Approval of Reserved Matters: Appearance, Landscaping, Layout and Scale following Outline Planning Permission Y/30/13 for 34No. dwellings, including 10No. affordable with access and ancillary works. Departure from the Development Plan.

Land South of Fellows Gardens Yapton

Thank you for your internet representation made on 25th April 2014 which has been recorded as '**an objection**' with the comments as follows:

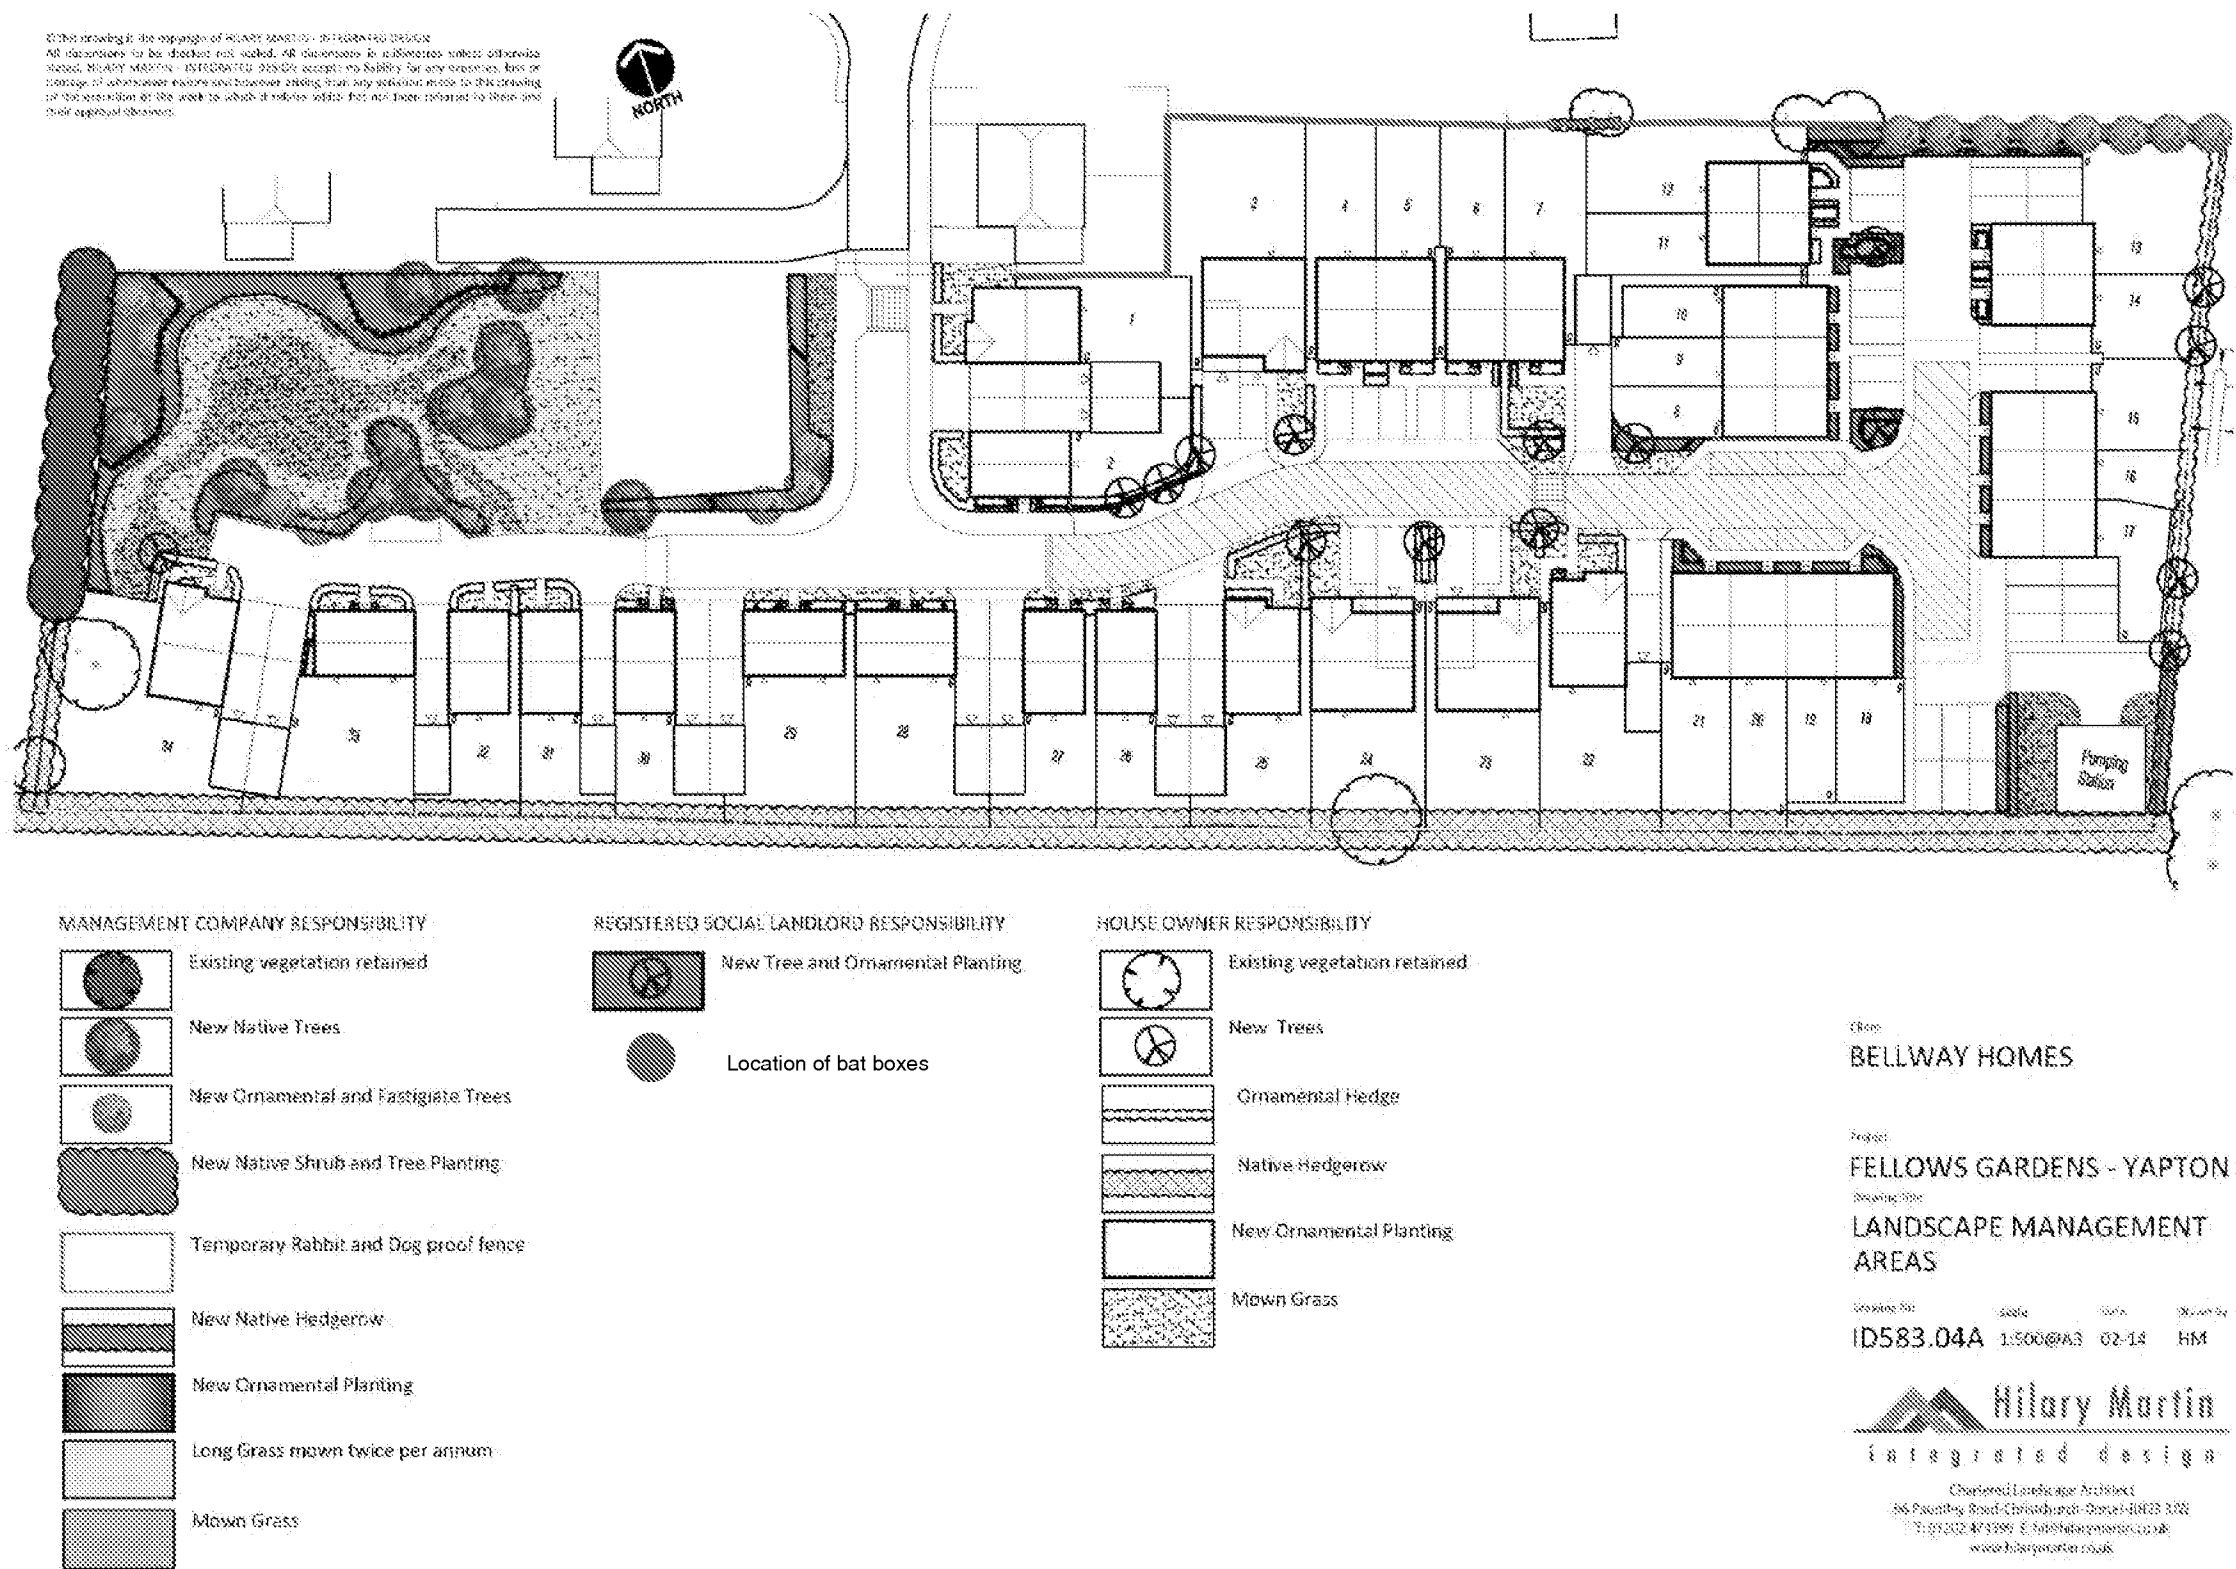
The Eco-management plan indicates that the northern boundary is composed of neglected hawthorn bushes which Bellway intend to pollard to a height of 2m. Gaps between these neglected trees are to be filled by a row of bare root hawthorn transplants. The landscape management document contradicts this, showing the boundary to be composed of ornamental and fastigate trees.

Our mutual boundary is formed of several mature hawthorn trees as well as a thriving immature Ash tree of approx 7m height. These Hawthorn trees are sited on my side of the boundary - I do not wish for them to be reduced in height. replacements for storm damaged trees along this boundary have been unable to compete with the existing trees and all have failed eventually. I have no doubt that the proposed bare root hawthorns and or ornamental trees will either grow very slowly or not survive.

The Eco-management plan talks at length of dark corridors along the other boundaries but affords no comment regarding the northern boundary. The assumption seems to be that the neighbouring gardens are of little value to wild life. My garden has been managed over a 20year period to provide a varied habitat in which wild life can thrive. By day, I have recorded a large number of species of bird in the garden, as well as frogs, newts, slow worms and voles. By night I have frequently observed bats hunting across the lawn. I do not know their origin but my best guess is the flint built outbuilding close to the Bellway development.

PLANT SCHEDULE TO ID583.03

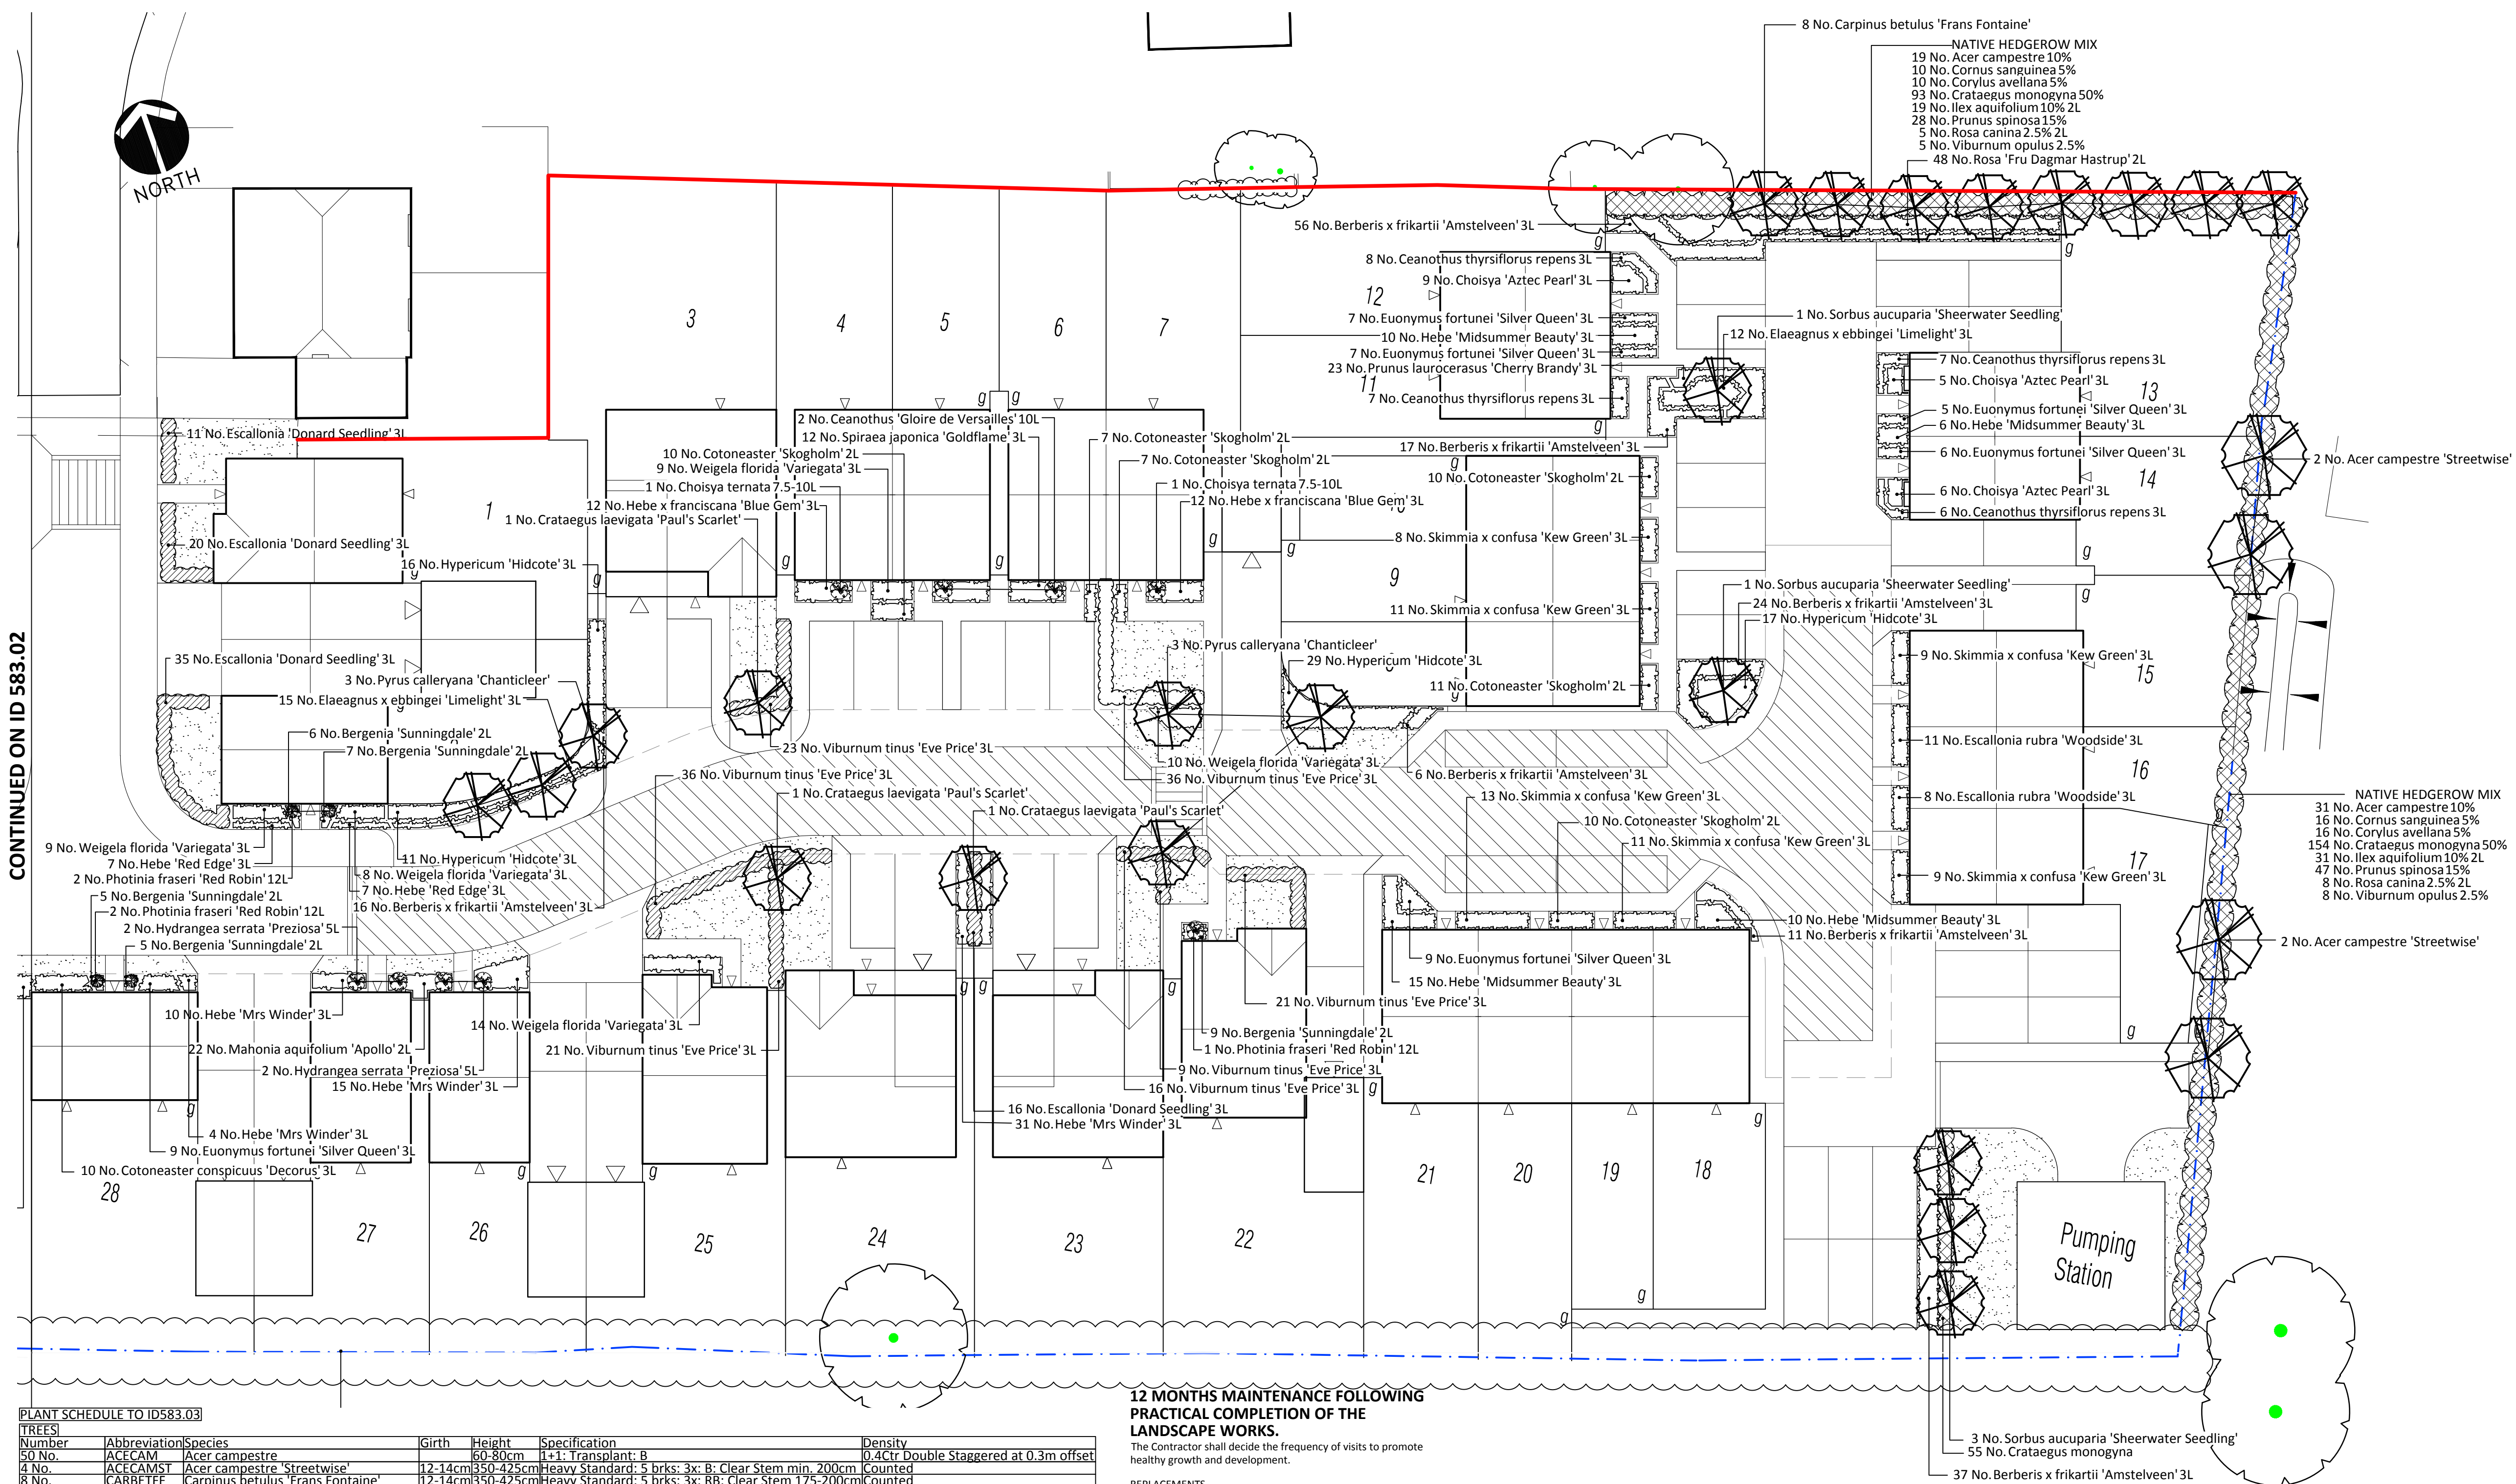
The description "ornamental and fastigate trees" is subject to a very wide interpretation. I would be happy to see fastigate (English) Oak, Hornbeam or even some of the Acer family (William Caldwell for one). I object strongly if their intention is to plant a row of wildlife sterile Cypresses.
